Part 3A Development for 8 Hearn's Lake Road Woolgoolga

**MP 08-0005, The Pines Caravan Park
Lot 106, DP 1144462, No. 8 Hearnese Lake Road, Woolgoolga**

Major Project MP 08-0005 The Pines Caravan Park

Re: Proposed Extension to Existing Caravan Park at Lot 2 DP1031068 and Lot 2 DP1031968 – ‘The Pines’ 8 Hearnese Lake Road, Woolgoolga MP08_0005

Scale: 1:1000 @ A1 PROJECT No: P001  
 Date: MARCH 2009 ISSUE: DA  
 Designed by: DW DRAWN BY: AM  
 Drawing No: DA-03 REVISION: B

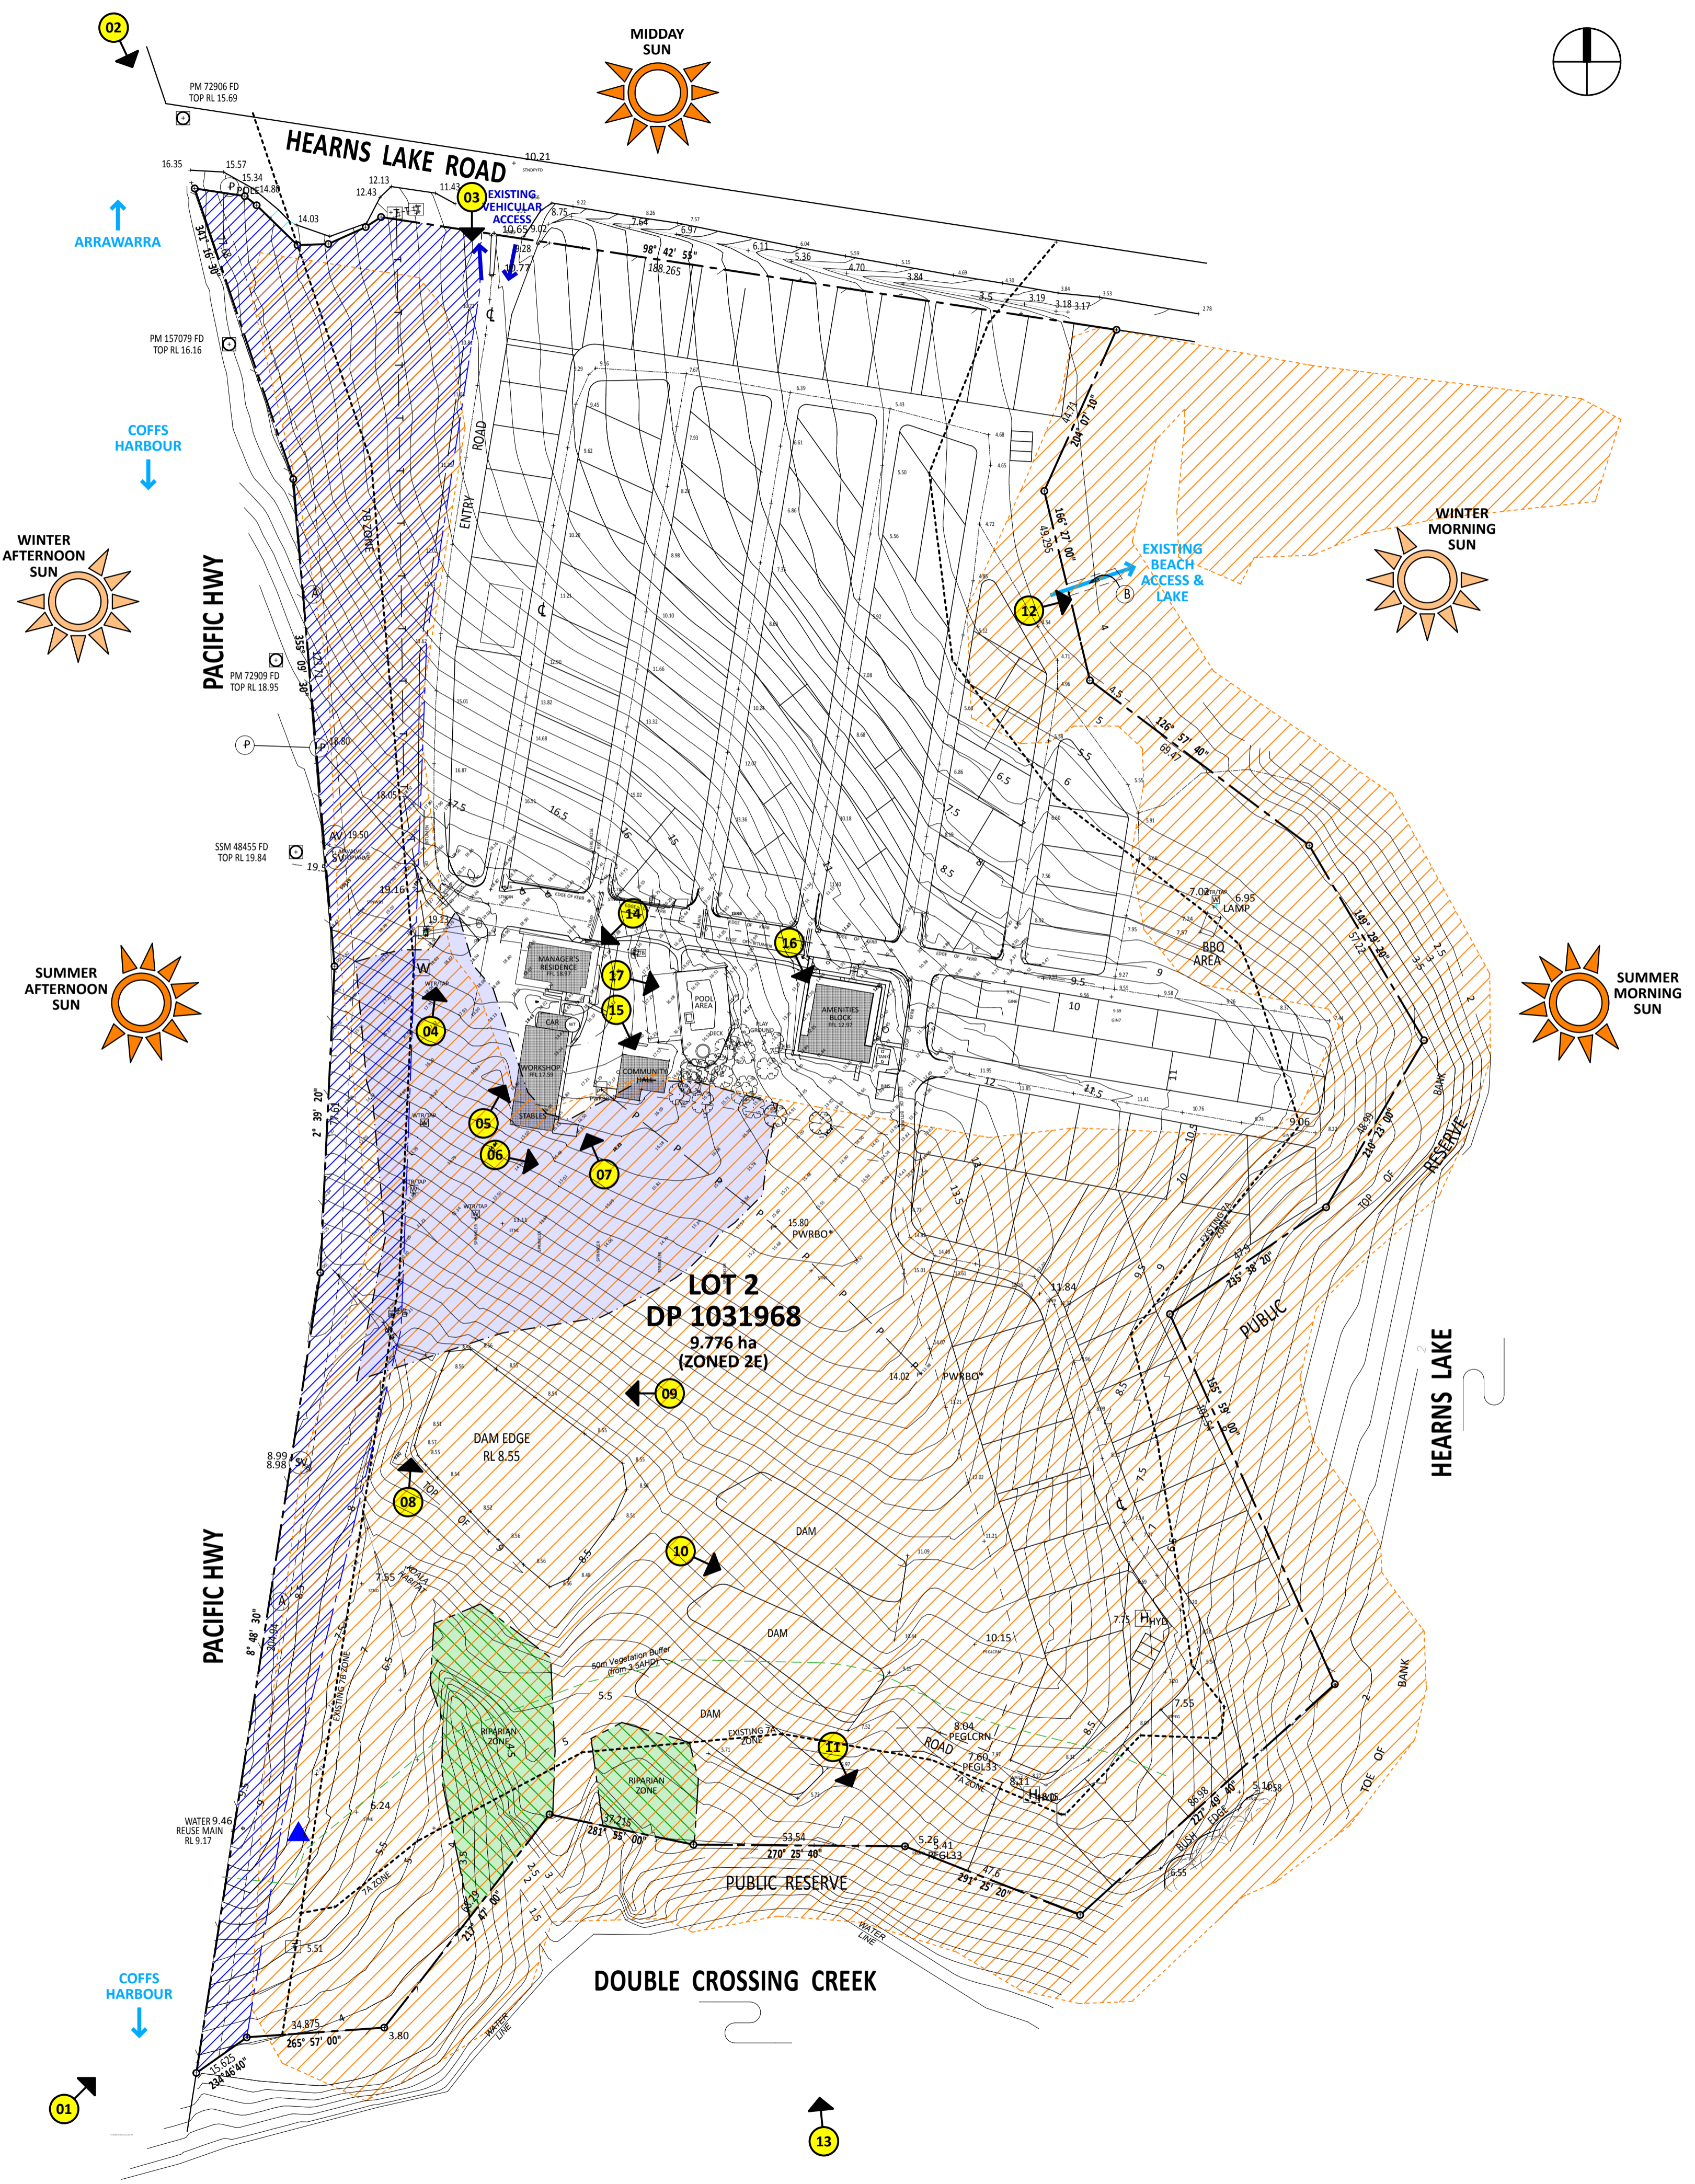
- A pathway and footbridge provide pedestrian access along Hearnes Lake Road from the Subject Site to this area (refer 'DA-03 Site Analysis Plan' – "Existing Beach Access & Lake").

- It is considered the EA does not adequately address the likely impacts a future expanded resident population may have on the public recreation area and residual section of Hearnes Lake Road through increased visitation and usage.

- LPMA would consequently welcome an opportunity to discuss the implications of the proposal for the future management of the public recreational area and residual section of Hearnes Lake Road in more detail with the Proponent.
